REPORT UPDATE

Application No: BR/306/19/HH

REF NO: BR/306/19/HH

PROPOSAL: Two storey side and rear extension, single storey rear extension & replacement front porch.

CLIENT	Mrs G Curtis	DRAWING	002 Proposed Plans & Elevations		
SITE	28 Arun Road, Bognor Regis	DATE	31 10 19	AUTHOR	AH
PROJECT	Proposed Extensions & Alterations	SCALE	1: 100 @ A3	STATUS	PRE PL

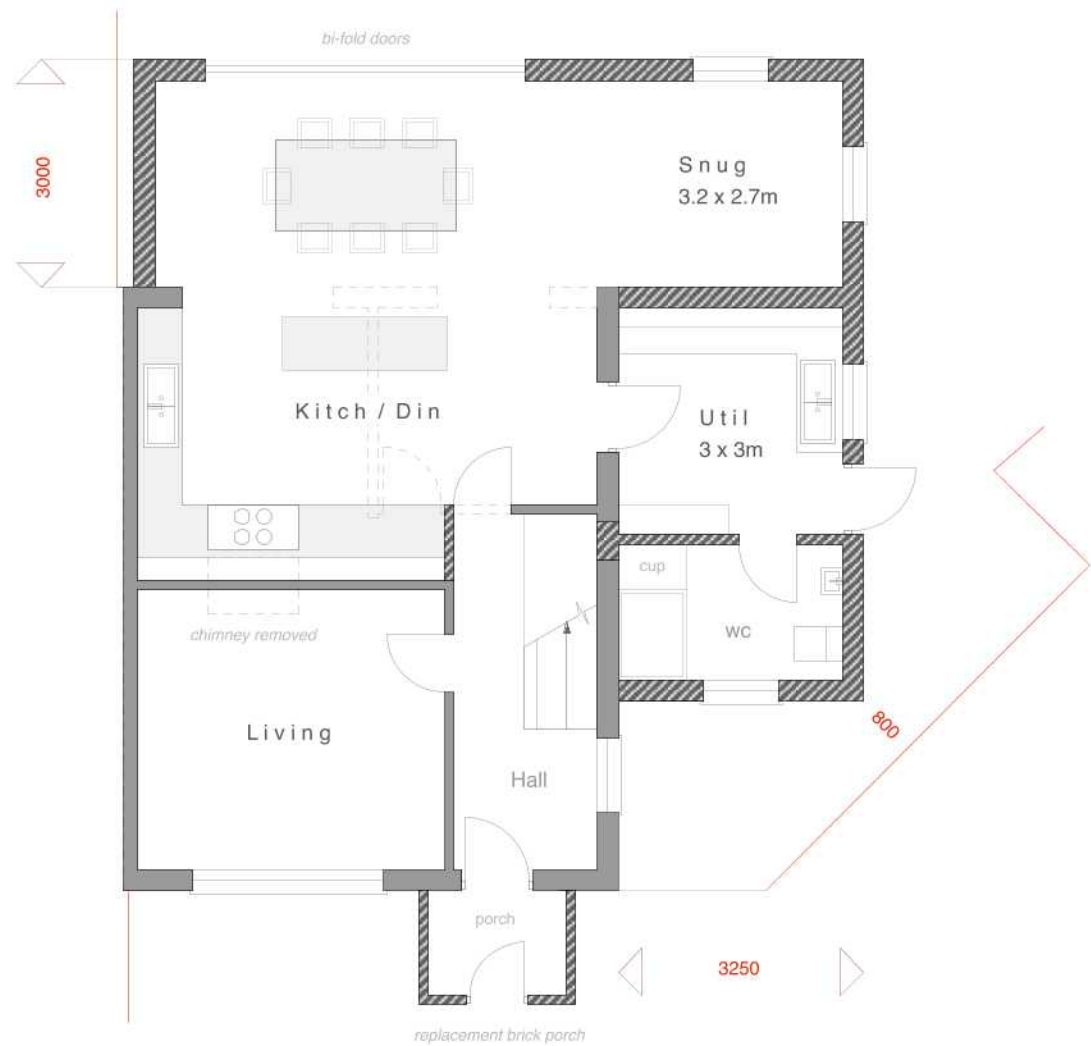
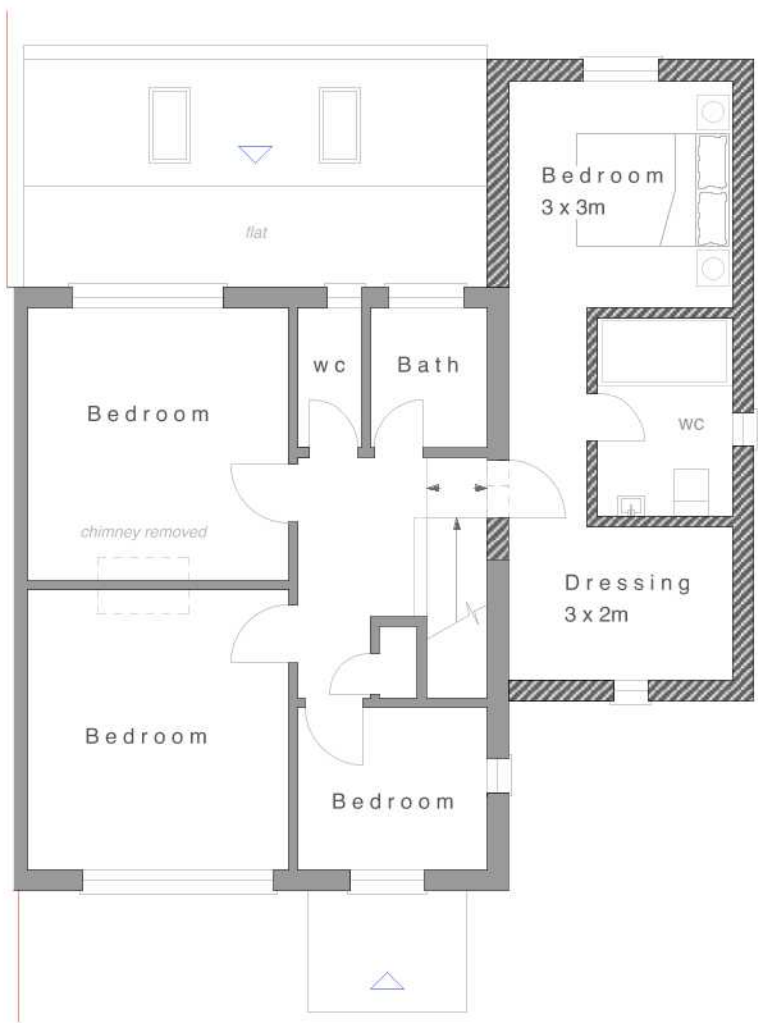
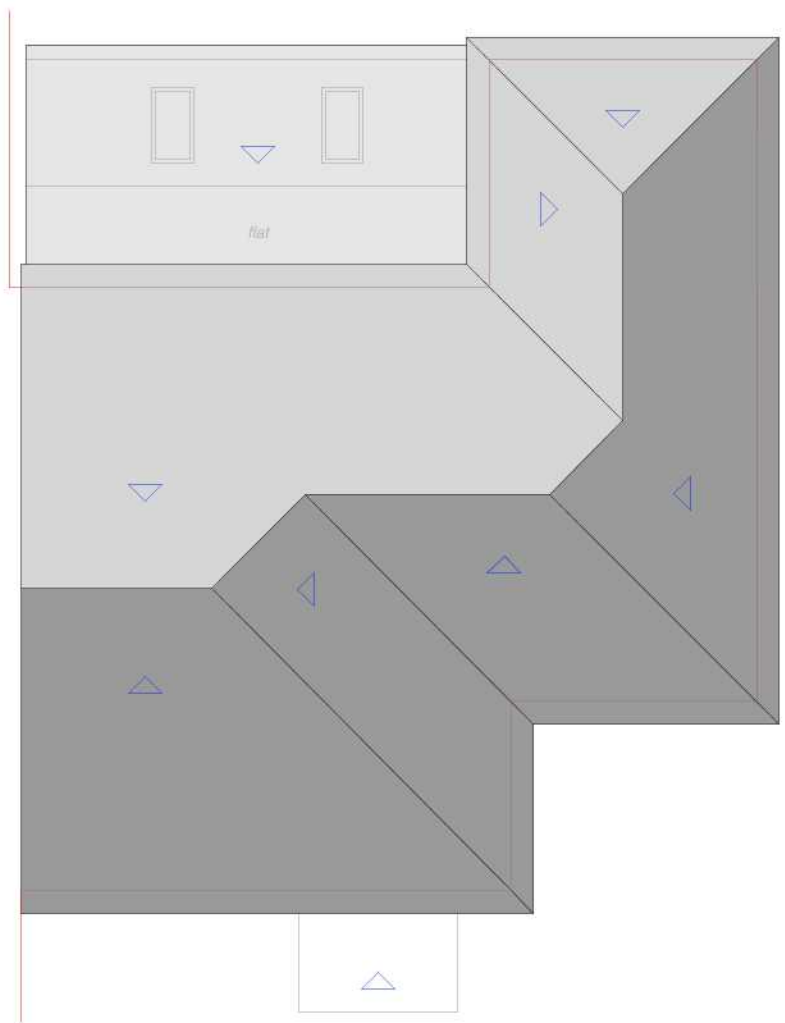
The development to the side and rear is large and as a result adds bulk to the property, however it is set lower than that of the host dwelling and is therefore considered a subservient addition. It also appears sympathetic in appearance with materials matching that of the host dwelling.

The proposal removes the existing front porch and replace it with a slight enlargement to incorporate the moving of the front door to the principle elevation. The roof will be changed to accommodate a lean to roof. This will have an eaves height of less than the original but a maximum height of 3.6m whilst this is high it is not considered to be a detrimental factor to the application.

The two storey extension has a hipped roof which sits just below that of the ridge height of the host dwelling. Whilst the addition adds bulk to the rear of the property, due to the siting of the development with the two storey addition sited towards the rear of the property, with a single storey addition to the north west, the development is not considered to give rise to significant impacts upon neighbouring occupiers. This includes that of the 45 degree rule. It is appreciated that the two storey extension does protrude to the rear and there will be some impact on the visual amenity from the neighbouring windows but due to the separation it is not considered to have an adverse impact.

There is a single window at first floor level in the side of the extension - this will be conditioned to be obscure glazed.

Reason: To comply with Section 91 of the Town and Country Planning Act 1990 (as amended).
- 2 The development hereby approved shall be carried out in accordance with the following approved plans:
 - Location and Site Plan
 - 002 Proposed Plans & Elevations
 - 003 Proposed Elevations
Reason: For the avoidance of doubt and in the interests of amenity and the environment in accordance with policy D DM1 of the Arun Local Plan.
- 3 The first floor window on the south-east elevation of the building shall at all times be glazed with obscured glass permanently non-opening.
